**A30 Chiverton to Carland Cross – Full Written Representation of Cornwall Countryside Access Forum to The Planning Inspectorate**  
**13<sup>th</sup> February 2019**

**GENERALLY:** This representation is made on behalf of **Cornwall Countryside Access Forum**, and amplifies the points made in our initial summary Written Representation made on 7<sup>th</sup> November 2018.

Drawing Title: **RIGHTS OF WAY AND ACCESS PLANS APFP REGULATIONS 5(2)(K) SHEET 1 OF 8**

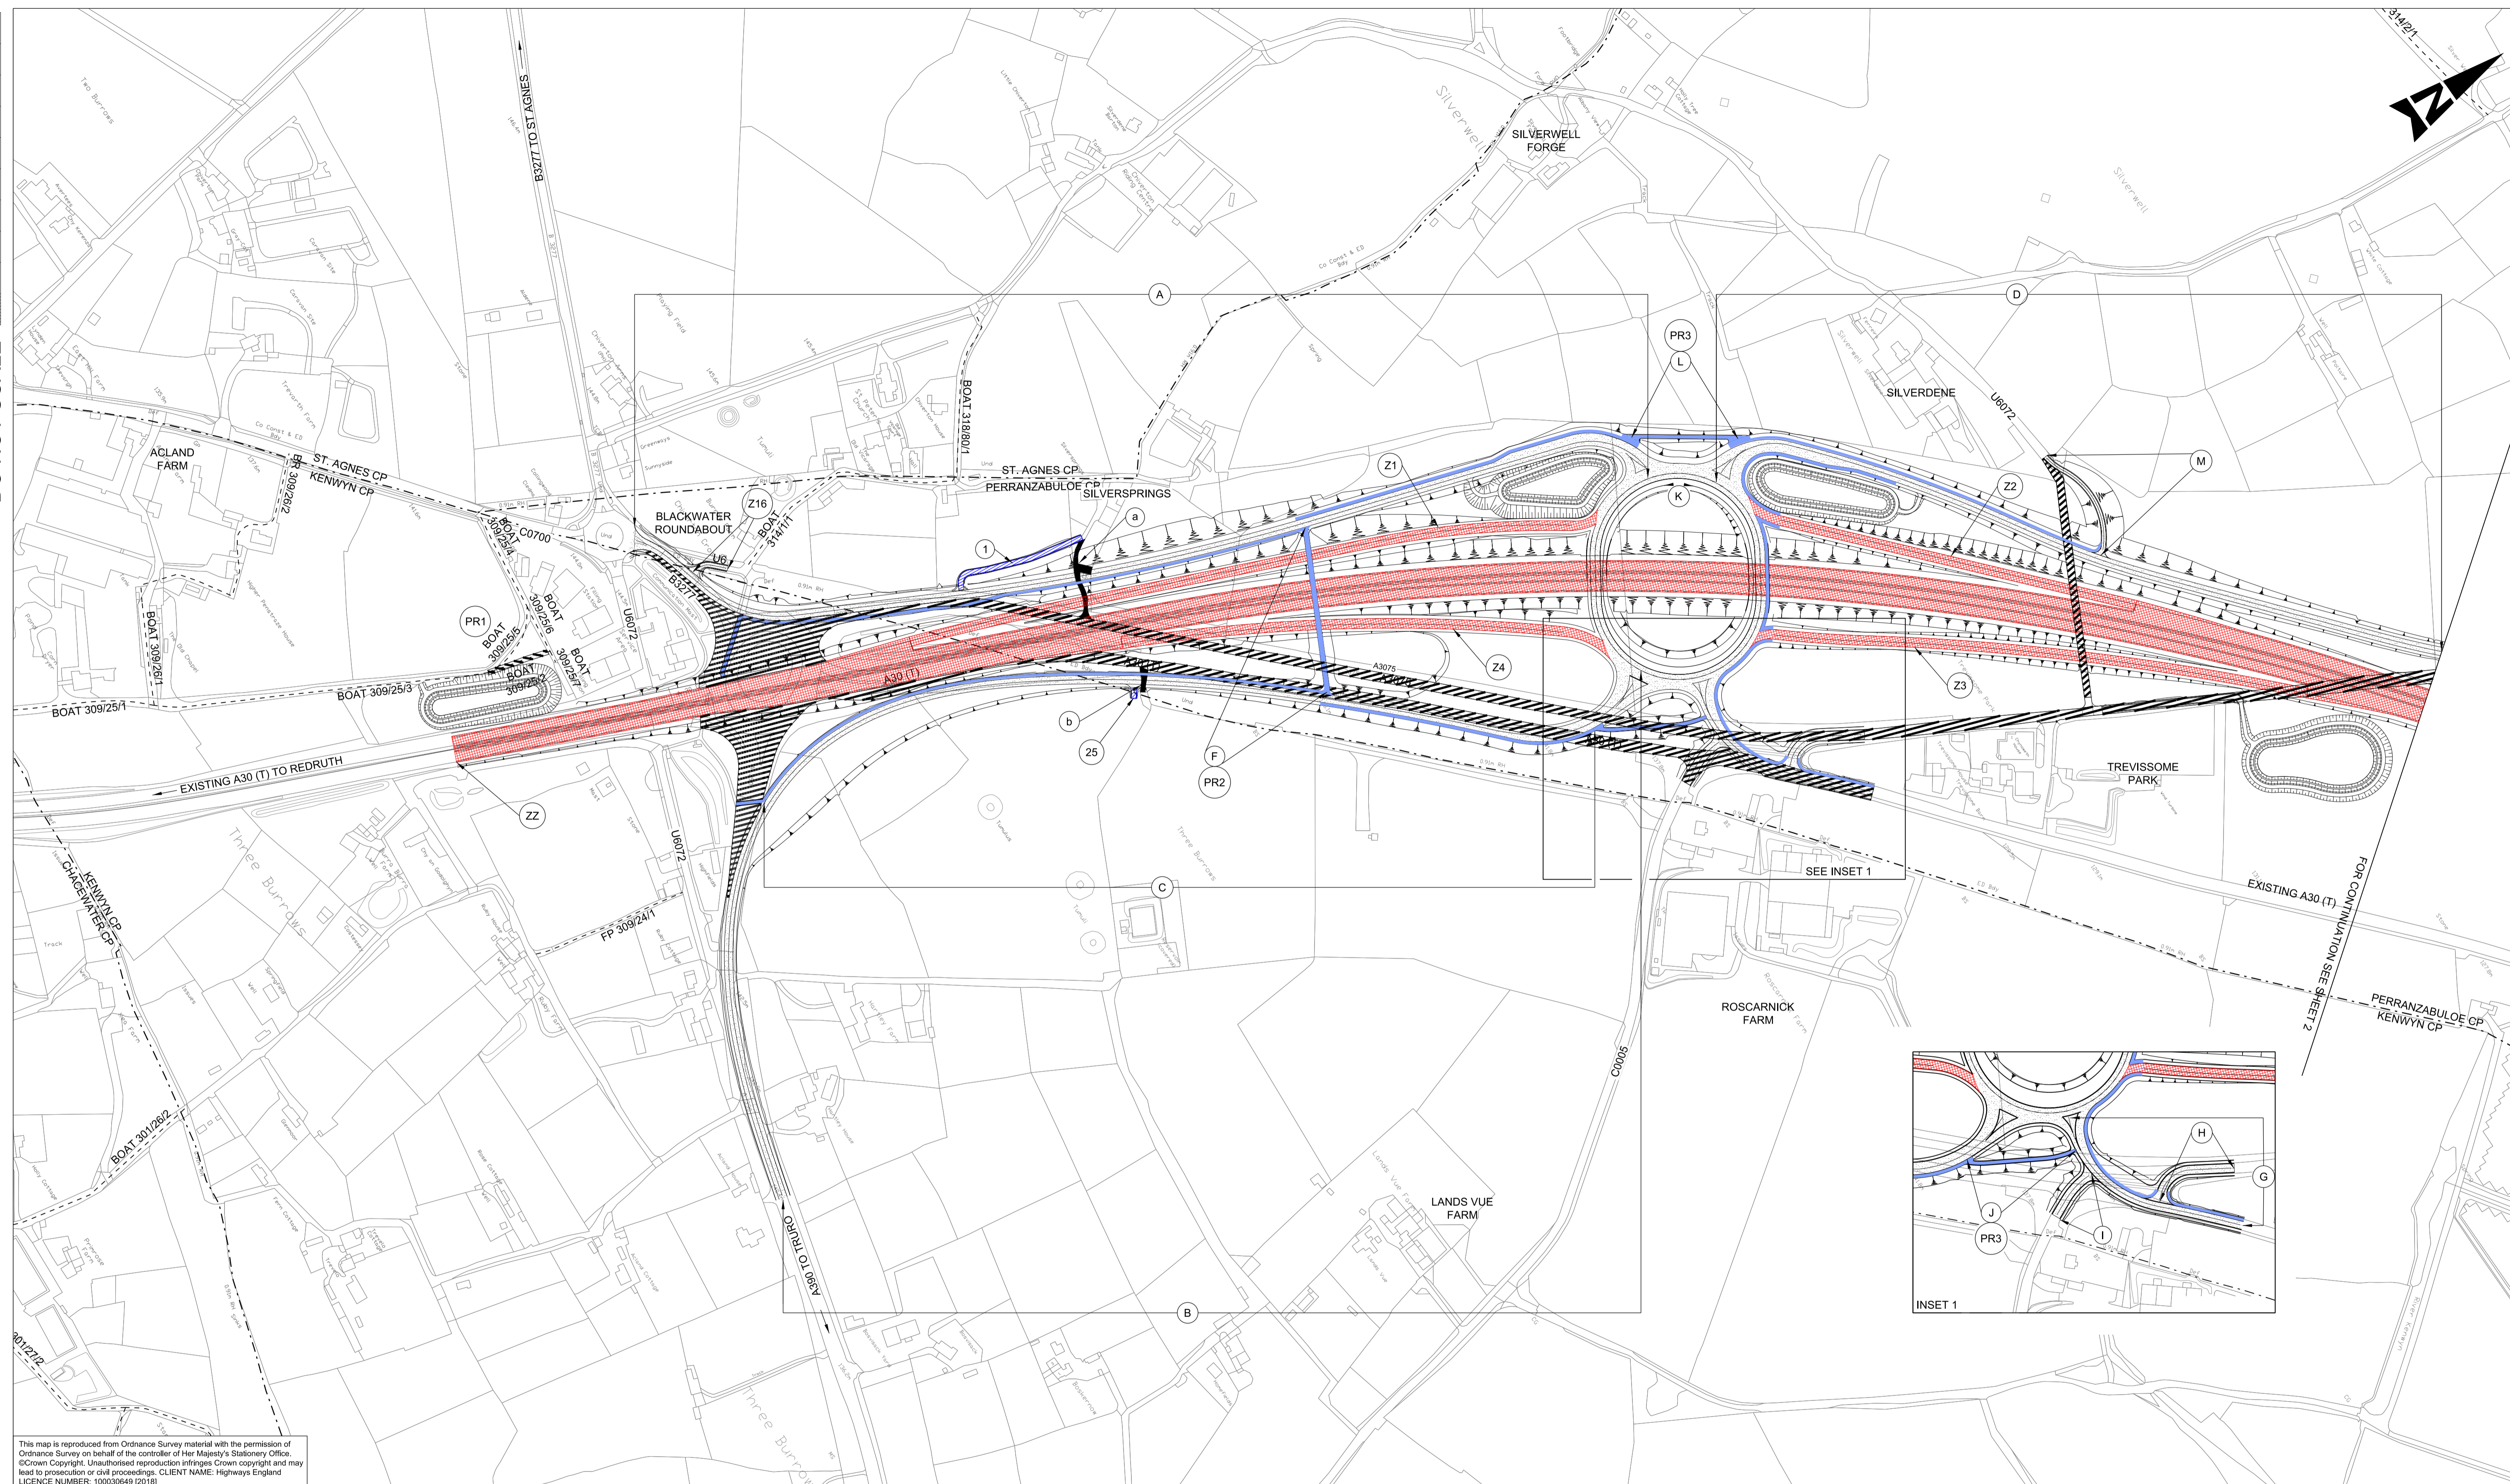
- a. **Signage provision for eastbound cyclists on A30** coming from West Cornwall – we are concerned on both grounds of safety and convenience that adequate signage provision is made to direct eastbound cyclists, particularly “End to Enders”, off the new A30 and onto the de-trunked old A30.

- b. **Chiverton Grade Separated Junction** – whilst 2m footway/cycleways are provided both to the slip roads and the gyratory, we are concerned on grounds of safety and convenience as to the detail of crossing provision, particularly at the roundabout, and would ask for consideration to be given to providing controlled crossings at the slip road and side road crossing points.

- c. **Proposed underpass for WCH (Ref: PR2)** – We have been told by HE that this will be 4m wide (inadequate), with 2.7m headroom (again inadequate) and 70m in length (too long). As a crossing place even for led horses, whilst much needed, it is not acceptable. We are concerned both for the safety and convenience of users, not only equine, but as this is a potentially busy cycle commuter route, for possible horse/cycle conflict. Of necessity it will have to be artificially lit, which is not really acceptable for equine users. The headroom provision is totally inadequate for mounted use by horse riders. As part of the St Agnes to Truro commuter cycle route the underpass is approximately 600 metres off-line of route, and therefore adds about 1.2km to the St Agnes to Truro commute. It is our advice that this underpass is both ill-conceived and inadequate for its intended purpose, and should either be totally redesigned, or scrapped. (See para. e. below).

- d. **Proposed WCH bridge on line of the A390 – B3277 Truro to St Agnes roads** – Off the record indications are that HE are proposing an overbridge on the approximate site of the existing Chiverton Cross roundabout, as part of the Designated Funds works outside of the main scheme, which if true we welcome. We would advise that this

should be reconsidered as part of the main scheme (and funded as such). We understand that as a DF project it would have to be built in advance of the main scheme, at a greater height (to get clearance over the existing carriageway). We are concerned at a lack of information, but would advise that it needs to be designed for use by ridden horses as well as cyclists and walkers, with adequate track width and parapets sufficiently high to accommodate safe equine use.

- e. **Preferred solution:** We appreciate that there may be a matter of timing, but our preferred solution to the Chiverton Cross NMU problem, would be to scrap the proposed underpass, and to use the cost savings to at least partly fund the bridge, which should be brought into the main scheme. It should be as near the A390 – B3277 route line as possible, with links as required to the de-trunked old A30.
